Rezoning Transportation Analysis

Petition Number: 2023-095

Revision Log:

Date	Description
9-28-23	First Review (IW)
11-27-23	Second Review (ME)
12-20-23	Third Review (IW)
01-24-24	Fourth Review (KC)

**C200**

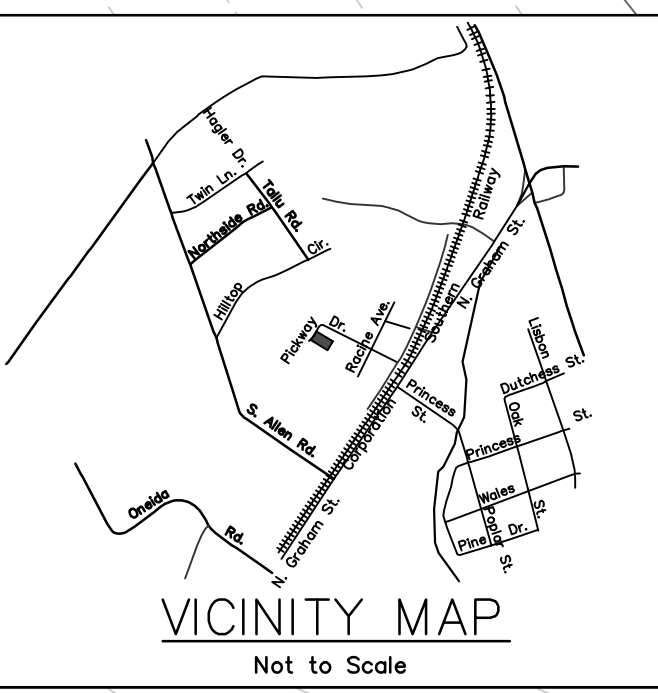
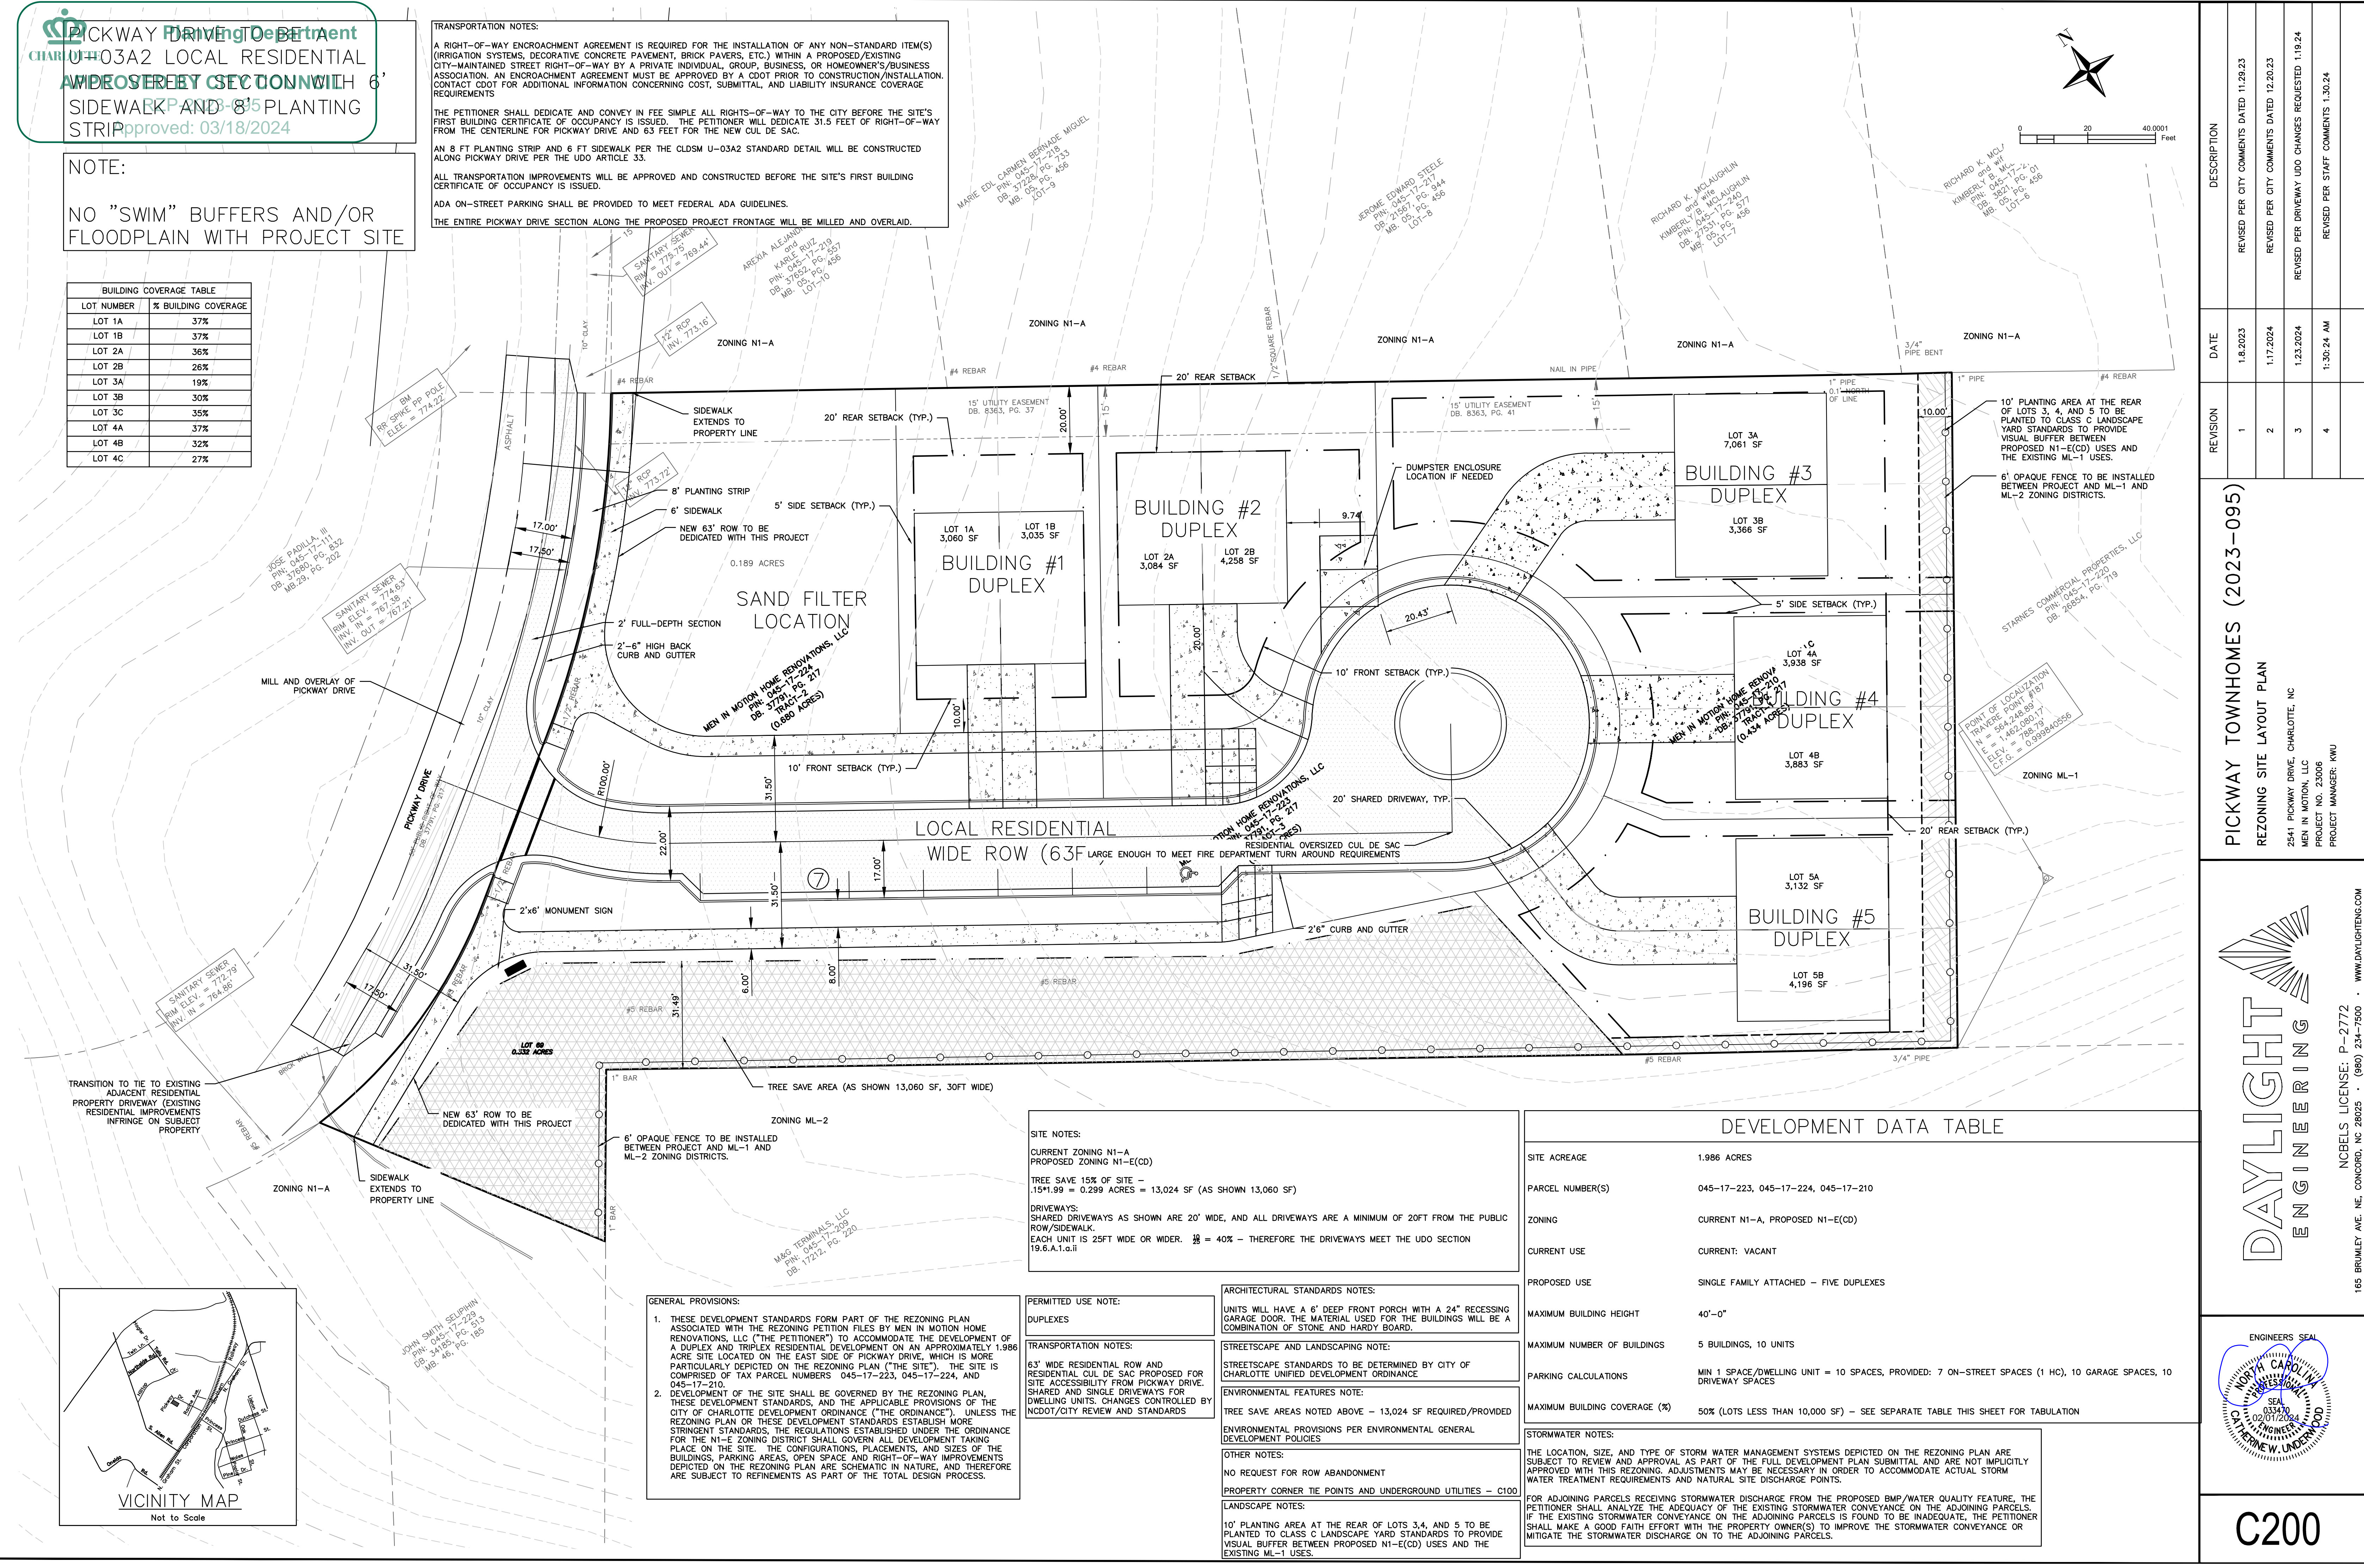
Clarifying Comment 01-24-24: Please revise site plan and conditional note(s) to commit to dedicate 31.5 feet of right-of-way. The site plan shall label and dimension right-of-way from the centerline of the road.

**C200**

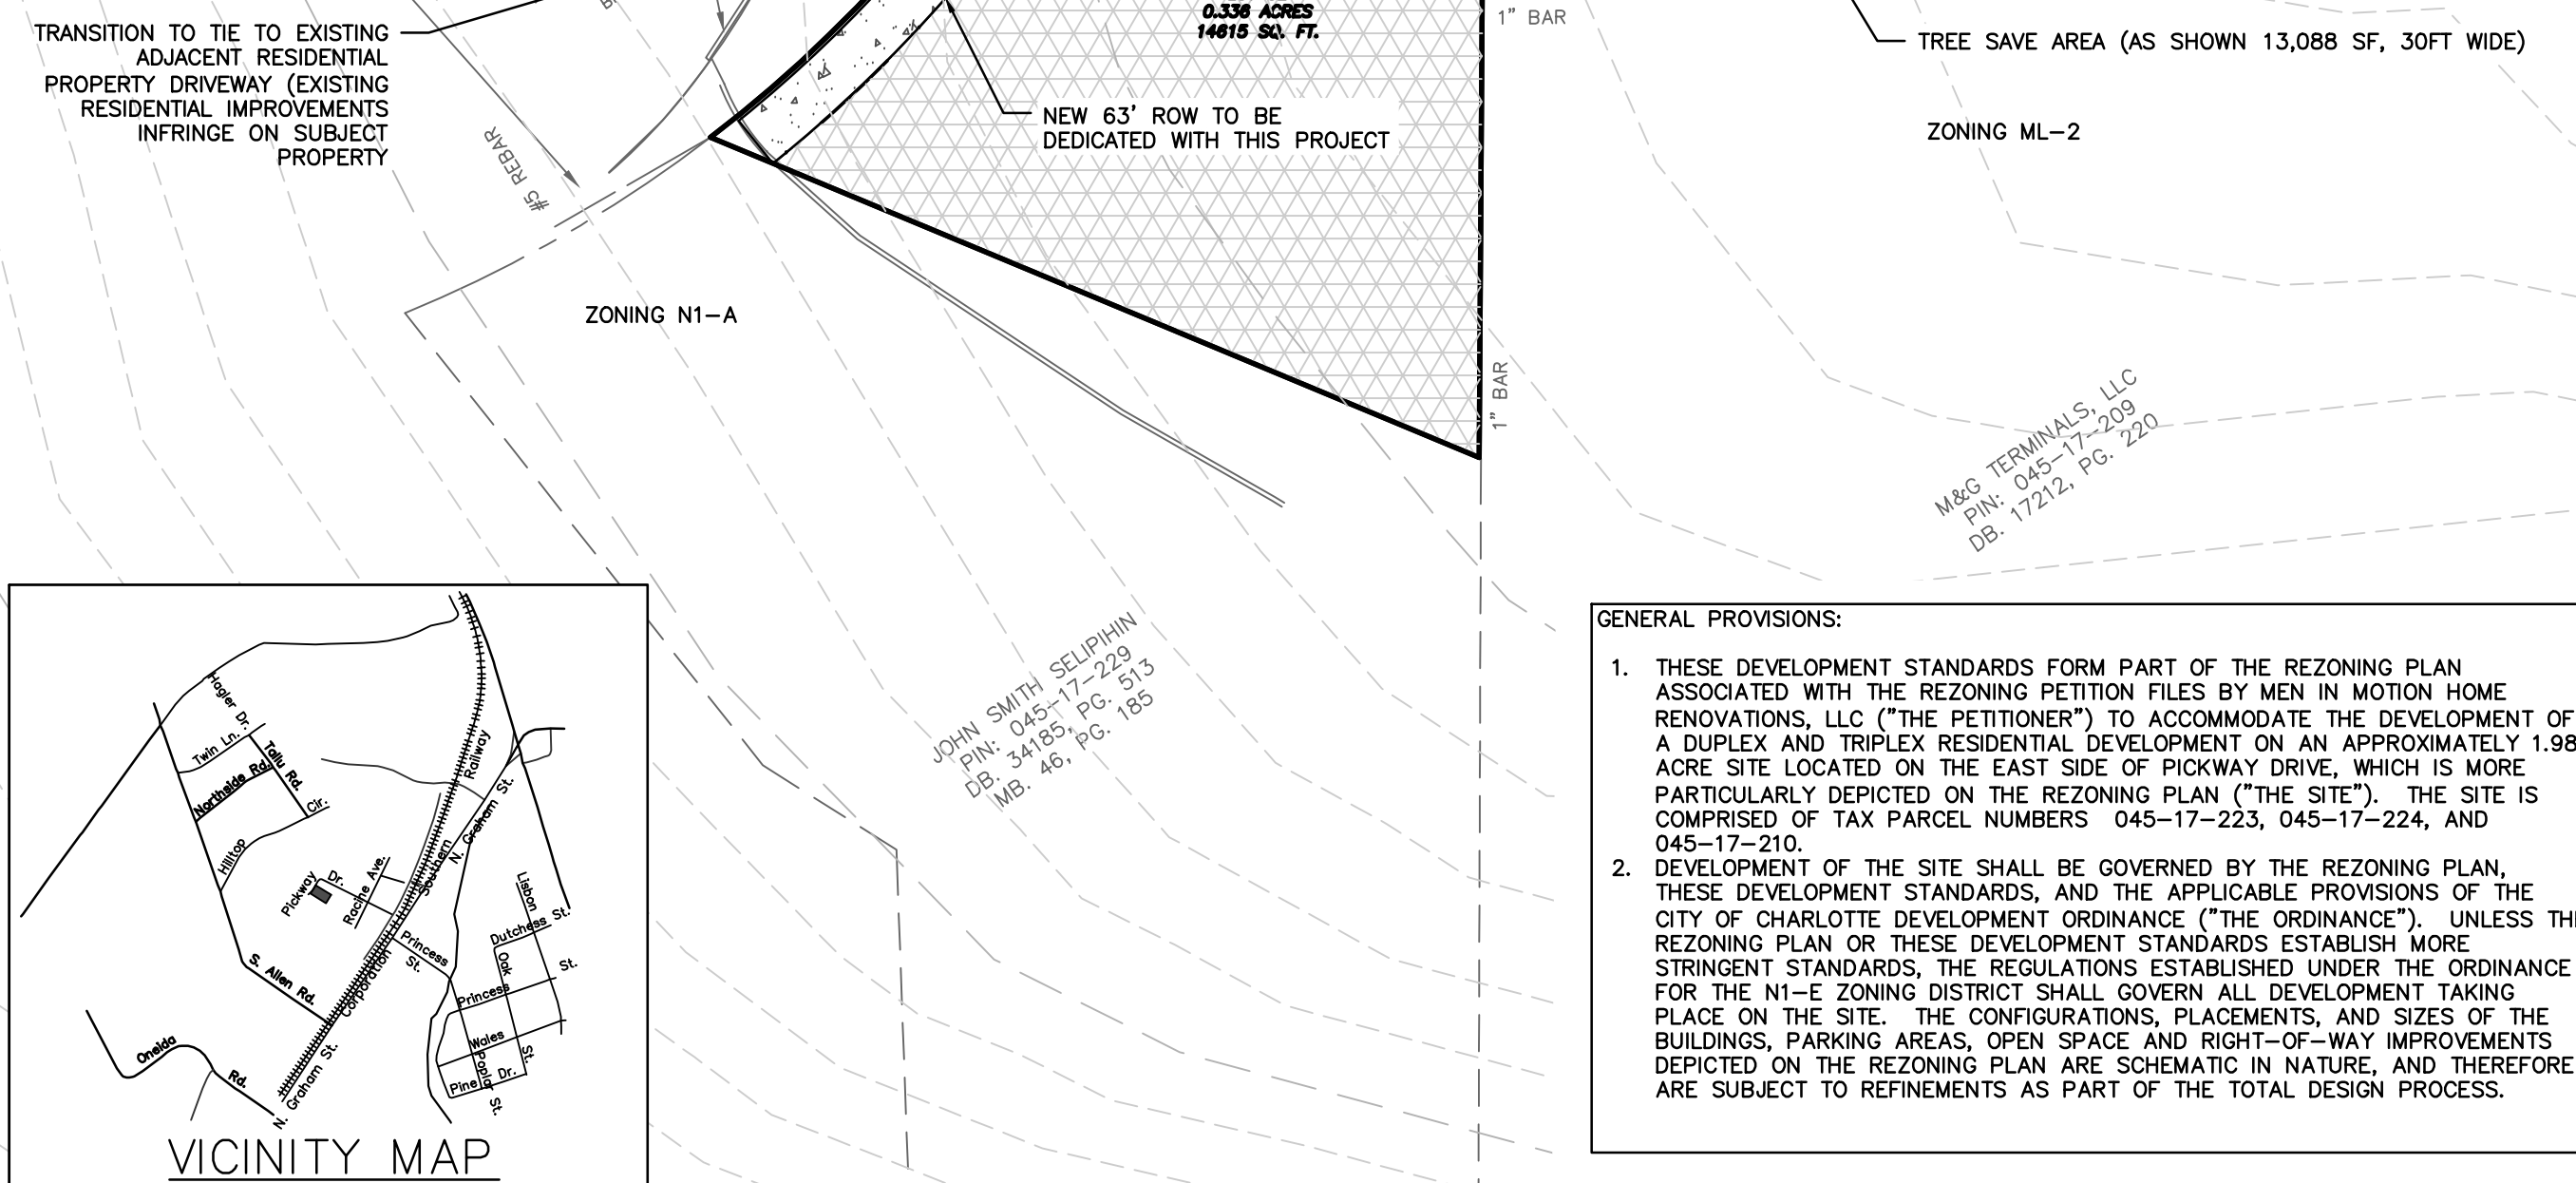
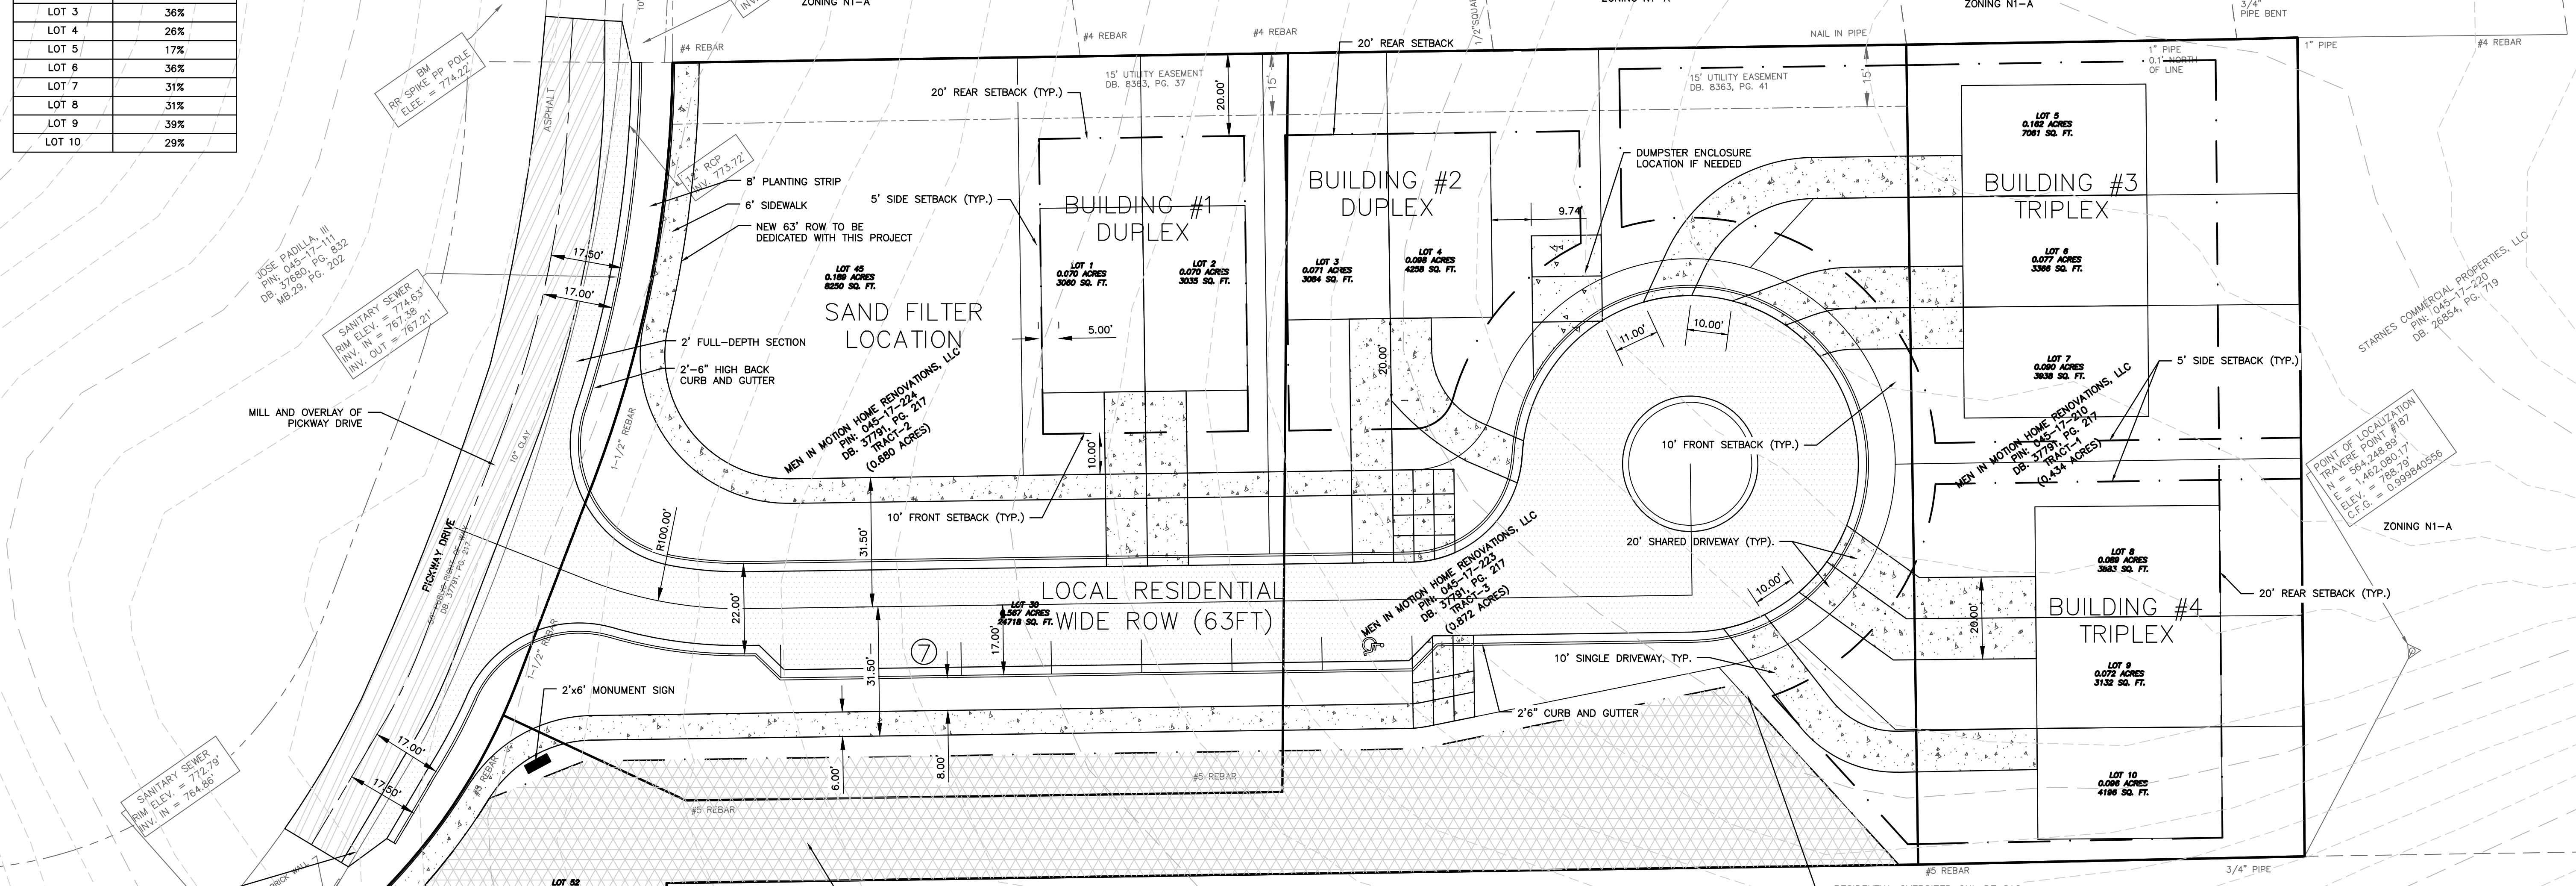
3. Outstanding Comment: Revise site plan and conditional note(s) to commit to dedicate 31.5 feet of right-of-way from the road centerline. The site plan shall label and dimension the right-of-way from the road centerline.

Clarifying Comment 11-27-23: Please revise site plan and conditional note to commit to mentioned right-of-way dimension with labeling and dimensioning from the roadway centerline.
